CITY OF ALBUQUERQUE

Re: 12TH STREET & MOUNTAIN ROAD OFFICES
1131 Mountain Road NW
Approval of Permanent Certificate of Occupancy (C.O.)
Engineer's Stamp dated 04/25/2005 (J-13/D83)
Certification dated 09/11/2006

Re: 12TH STREET AND MOUNTAIN ROAD OFFICES, (J-13/D83)
1131 Mountain Road NW
Permanent Certificate of Occupancy, Certification dated ??????

Re: ³ 12th Mountain Offices, 1151 Mountain Rd. NW - Grading & Drainage Plan
Engineer's Stamp dated 02-07-05 (J13-D83)

C-1

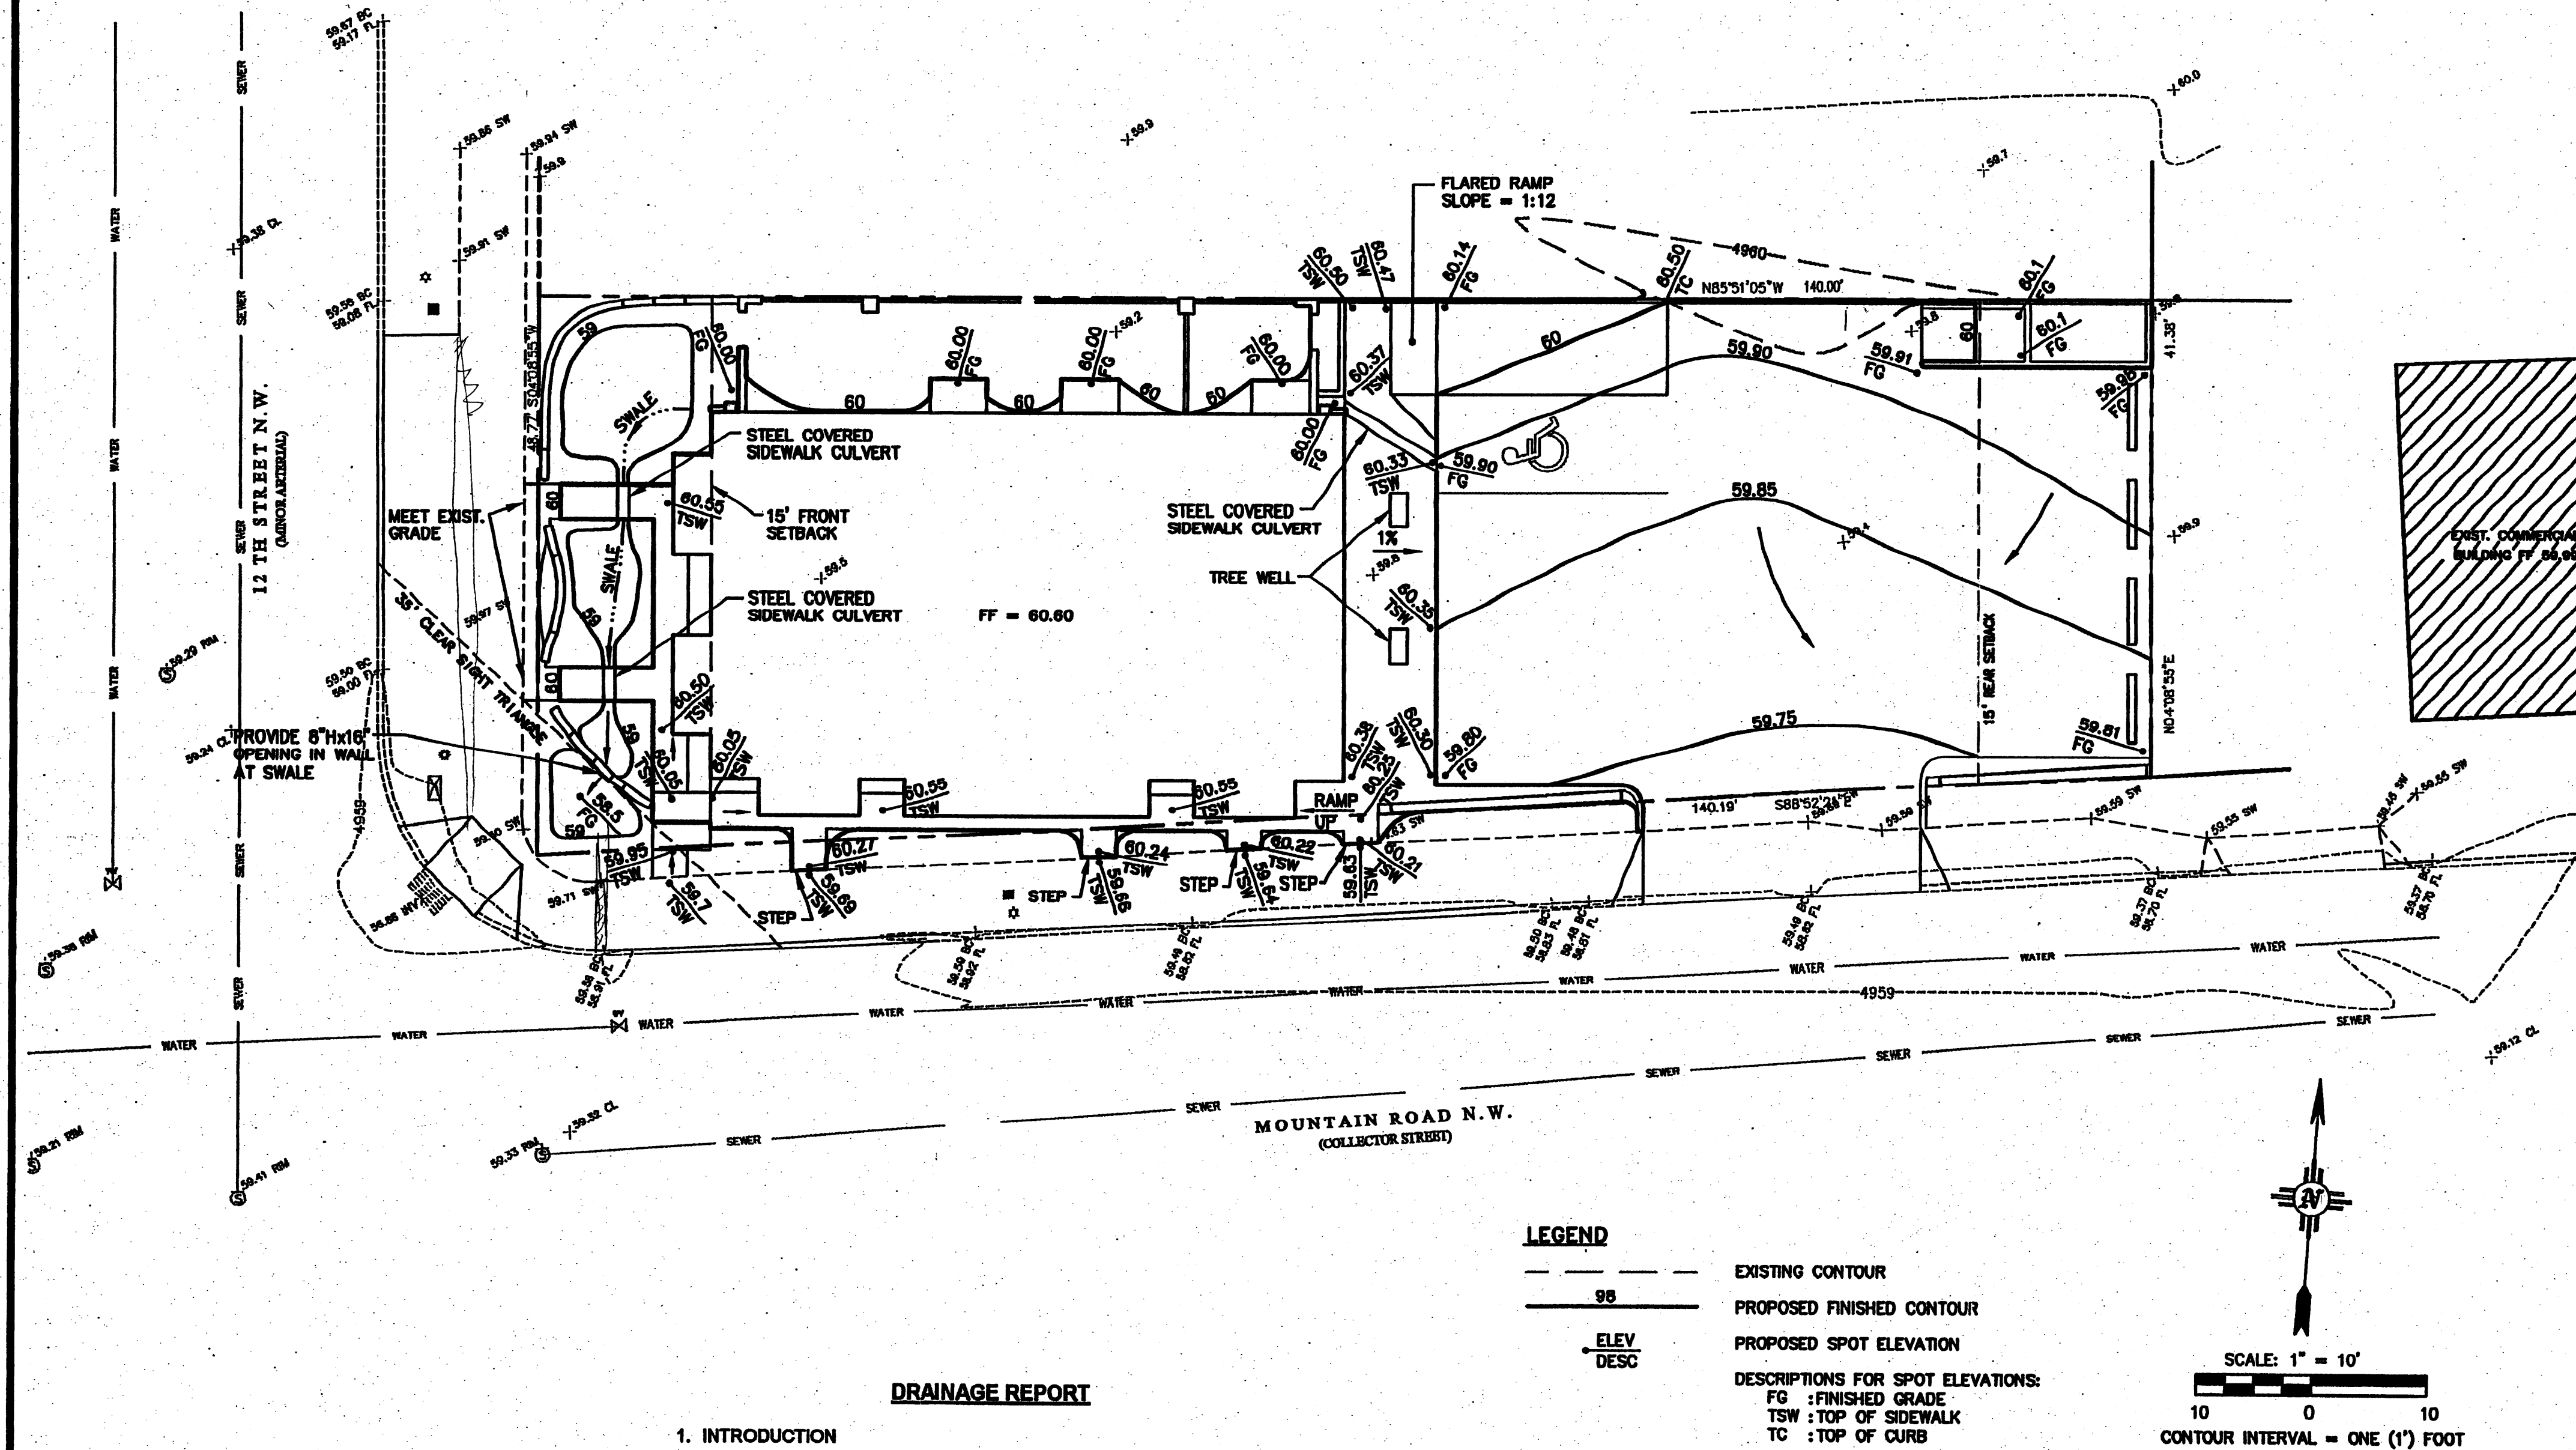
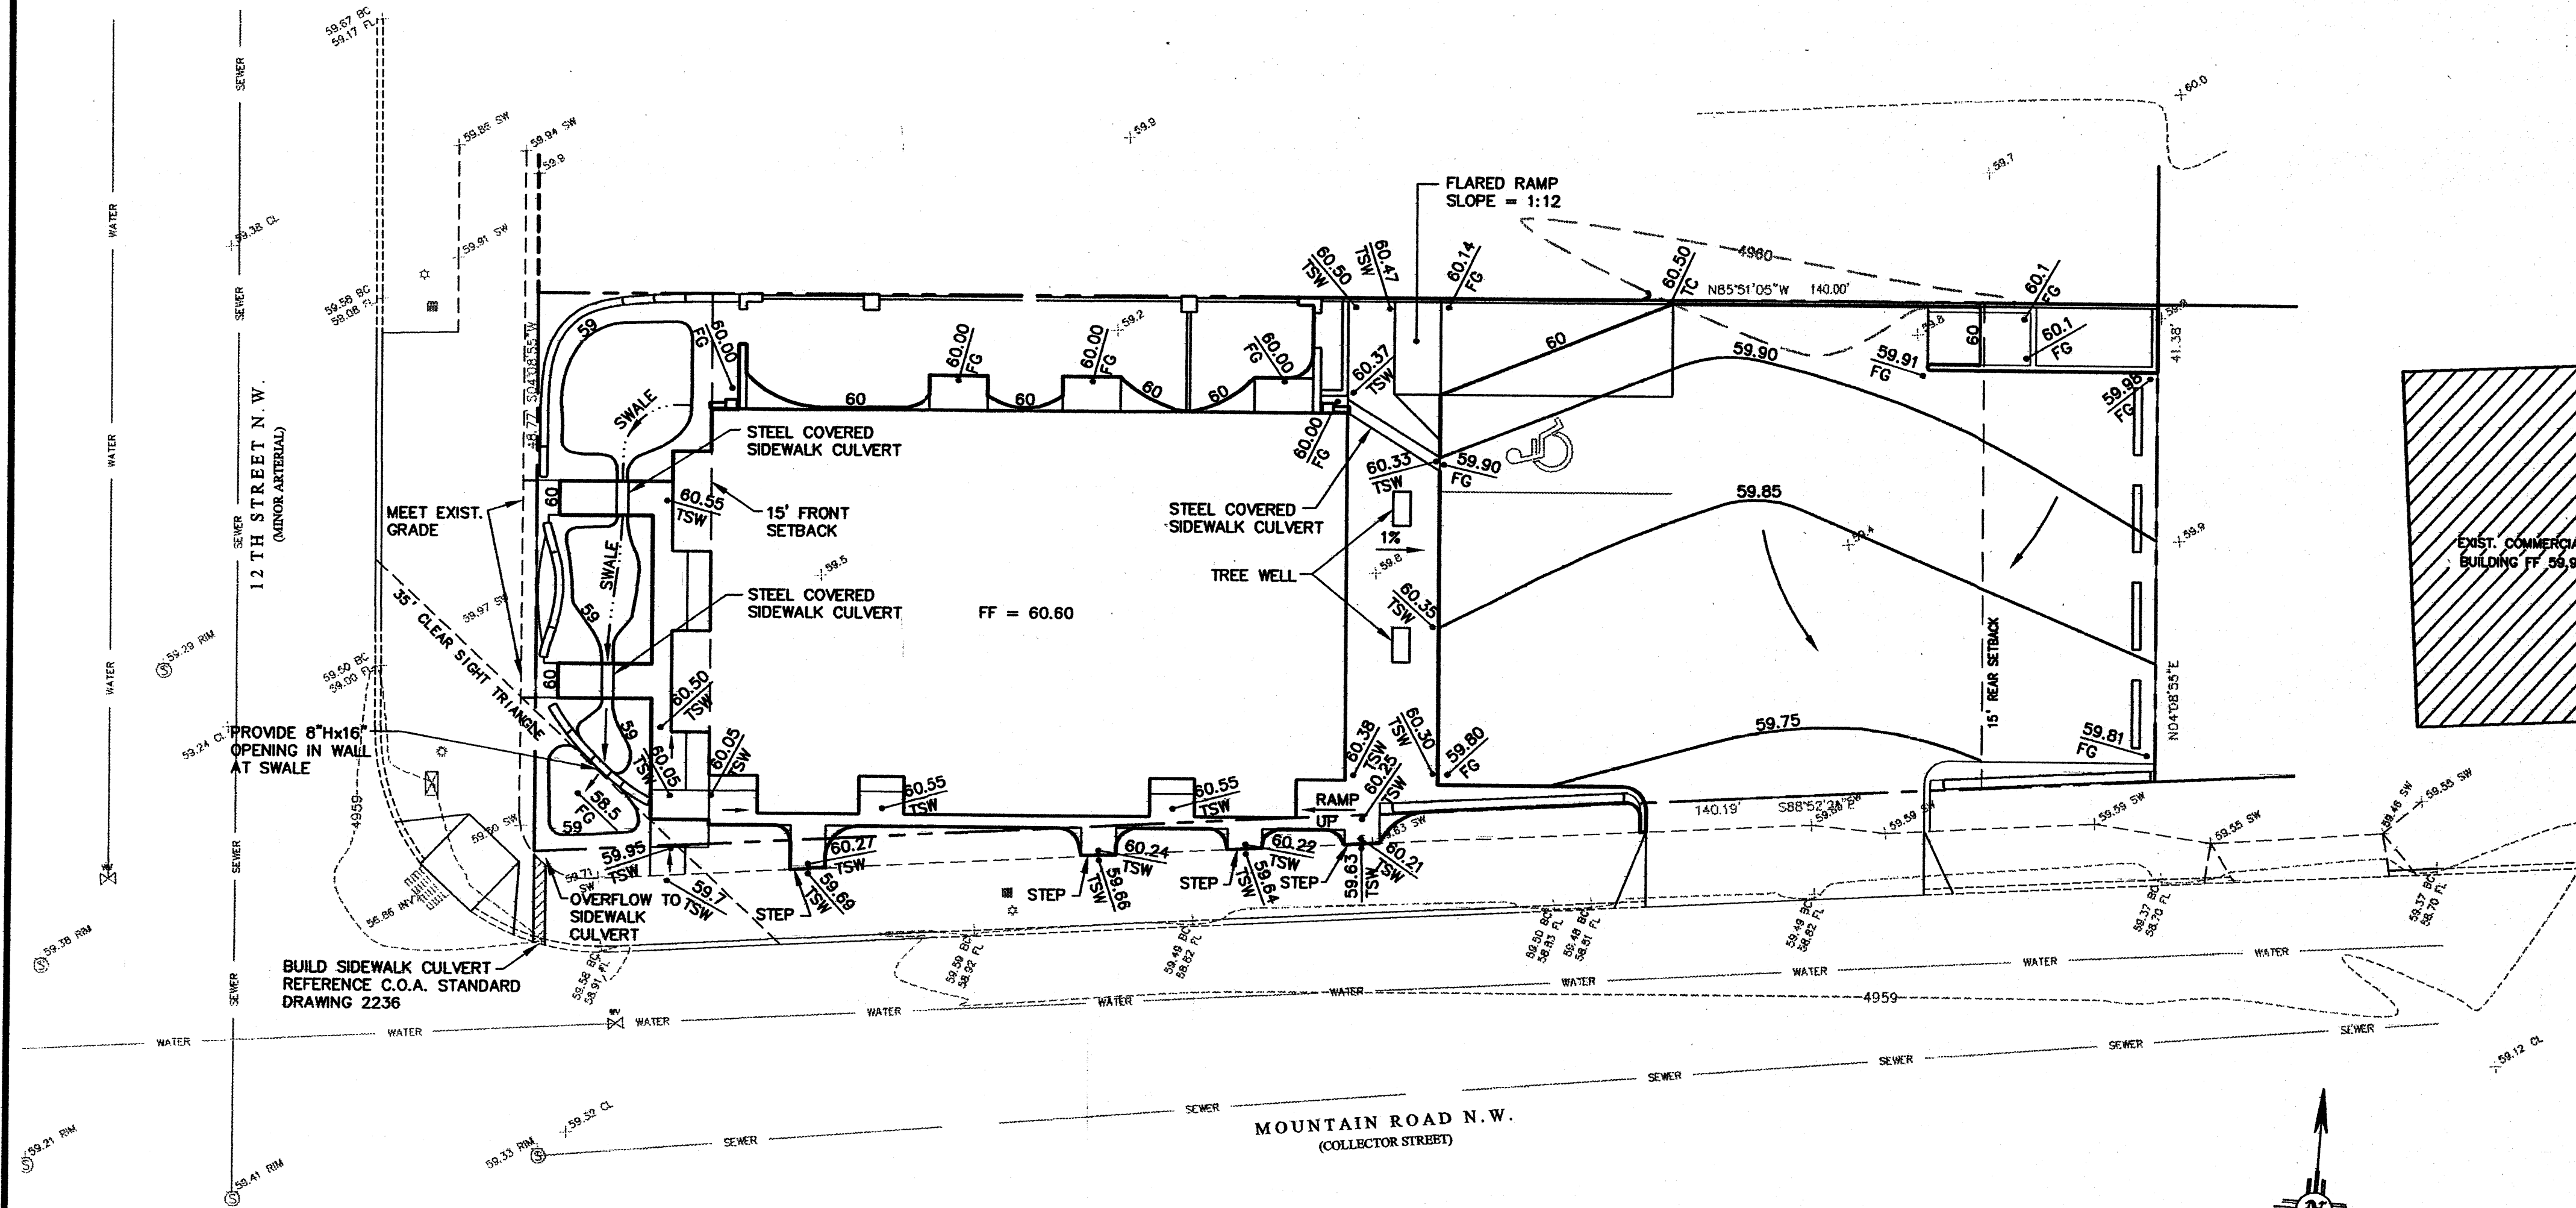
- The City does not allow storm runoff to flow over the public sidewalk. Add a sidewalk culvert (Reference C.O.A. Standard Drawing 2236) to the west side of the new building to convey the runoff to the Mountain Road.
- A SO19 Permit will be required for work in the City right-of-way. Add applicable SO19 Permit notes and provide us with two sets of plans.

- ① Construct sidewalk culvert at SW corner of property. See above.
- ② Construct swales and basins at West side of property. See above.

C-1

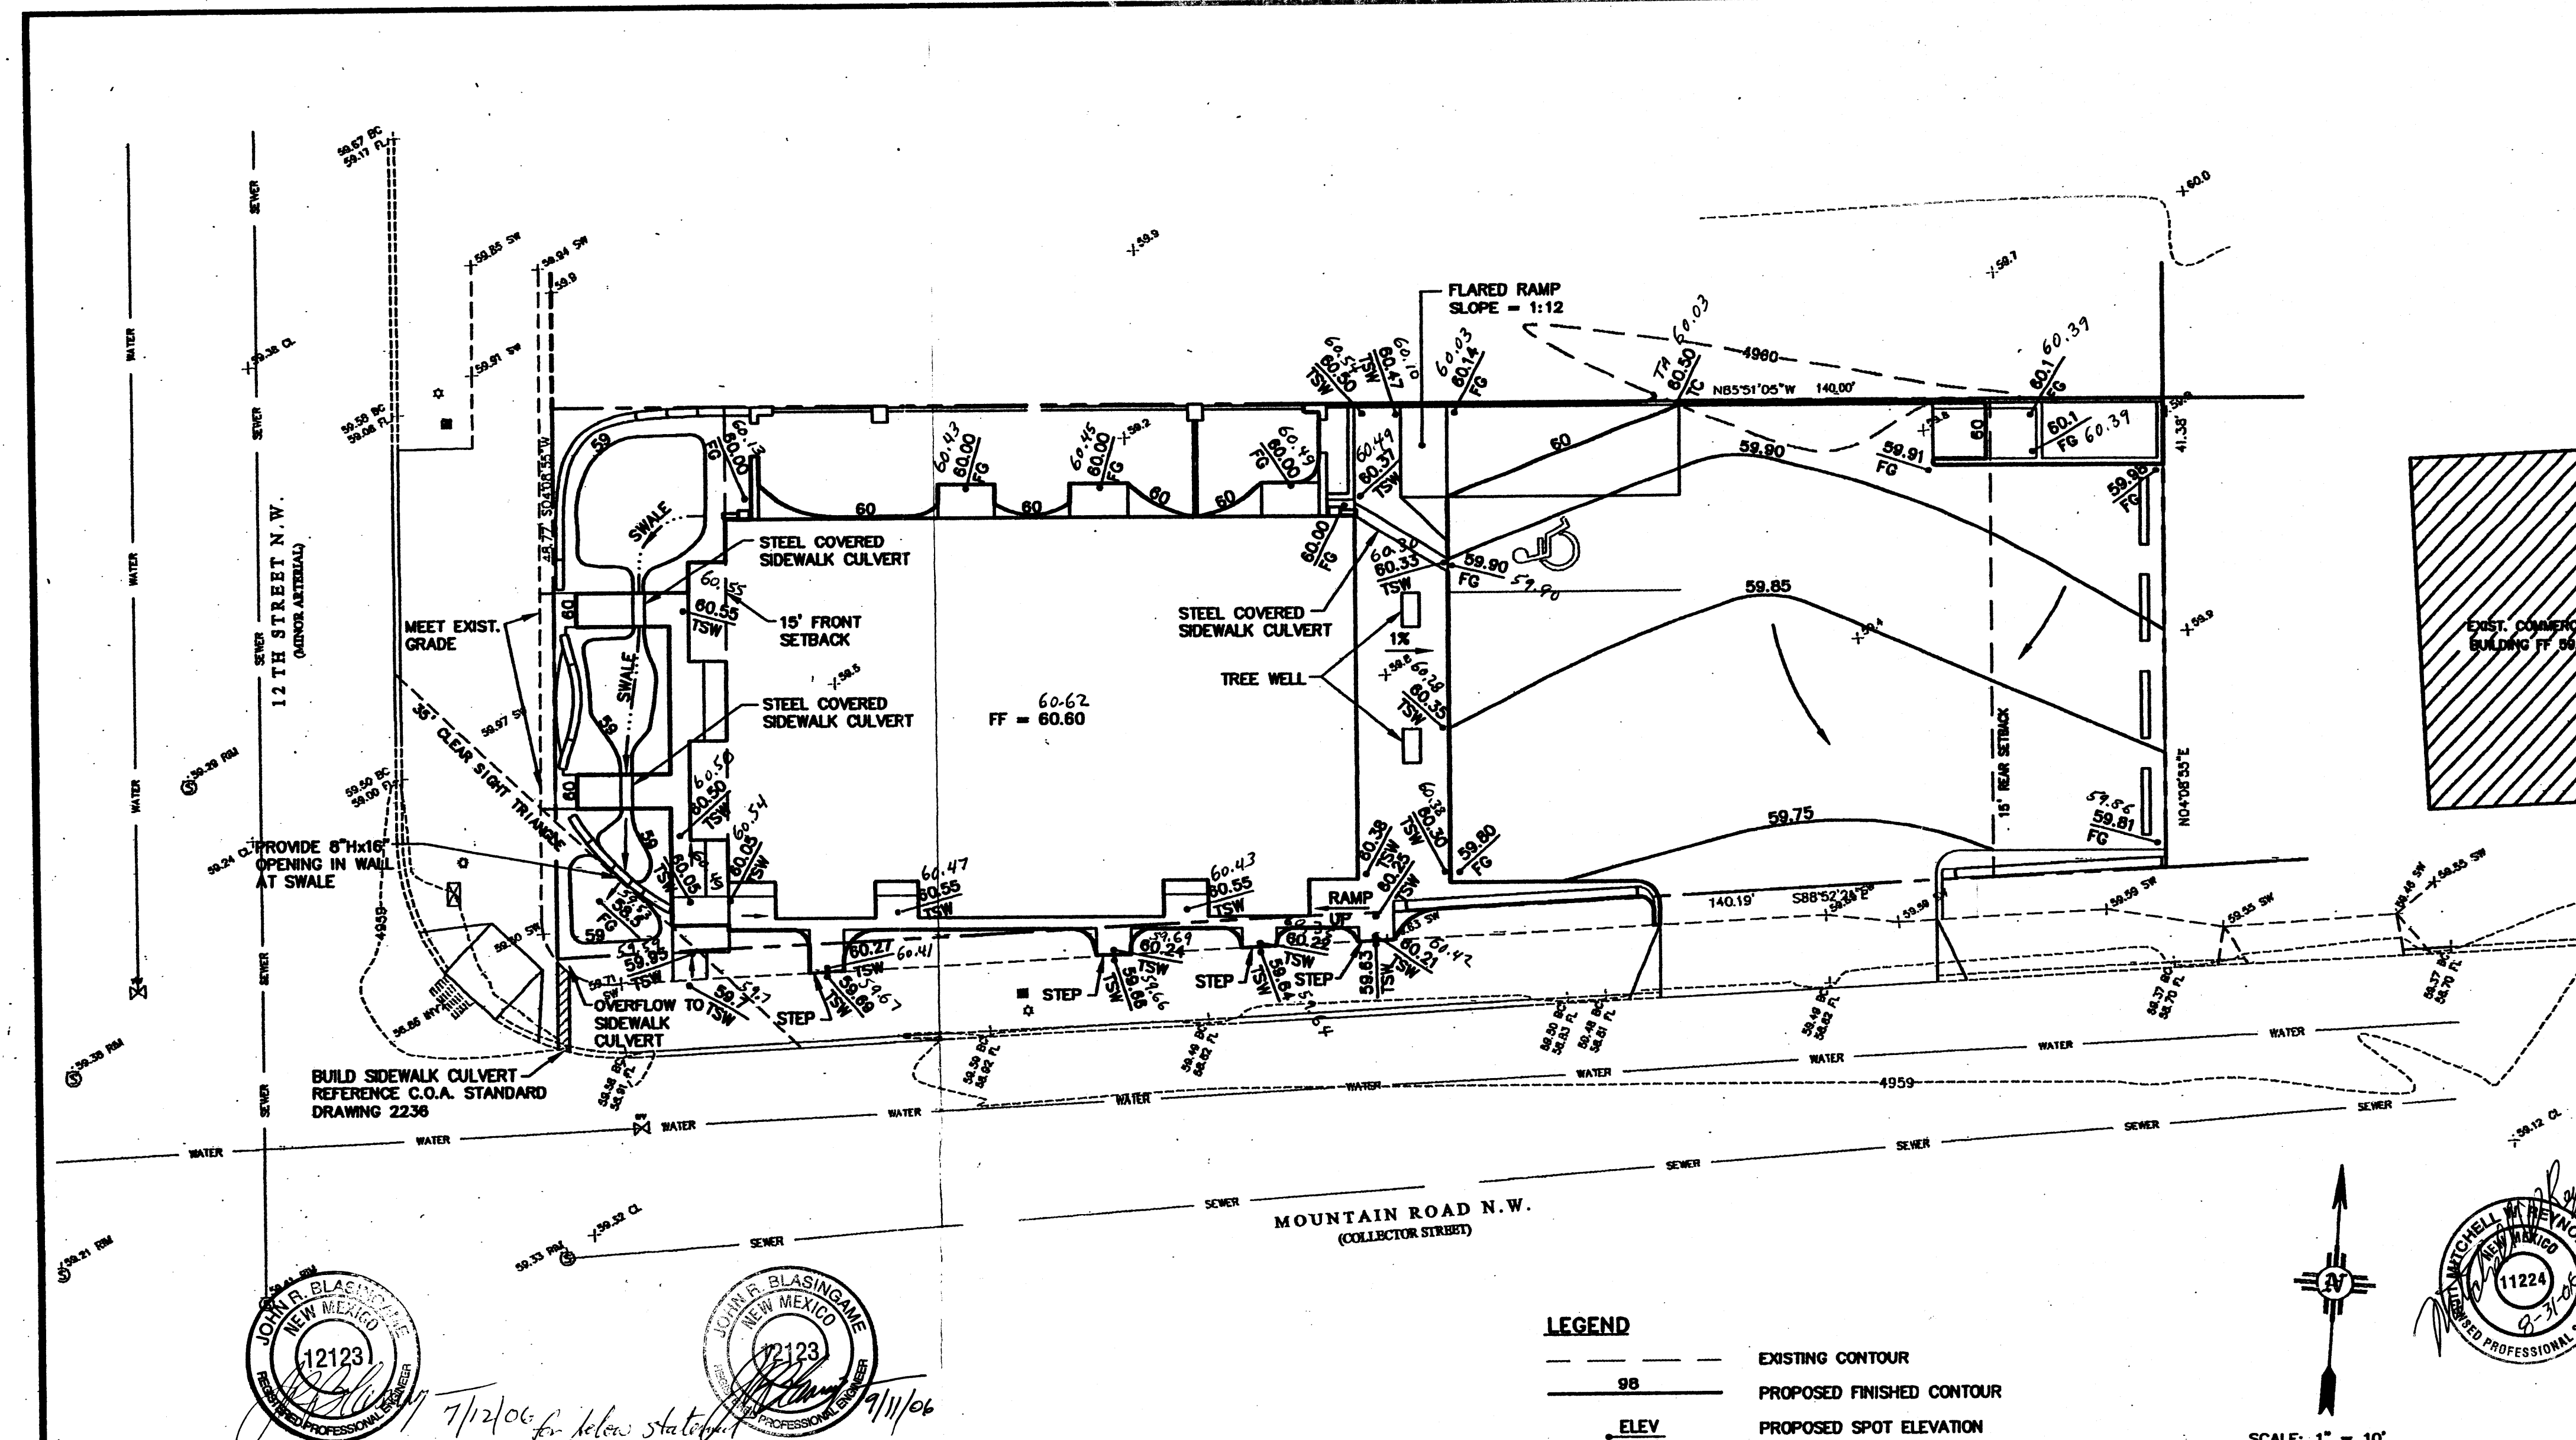
1. The approved grading and drainage plan has an Engineer Stamp date of 04/25/2005 not 02/07/2005 as indicated on the Grading & Drainage (G&D) Plan submitted today. (See attached copy of G&D Plan approval letter). Also, the as-built elevations and certification must also be on the copy of the Approved G&D Plan.
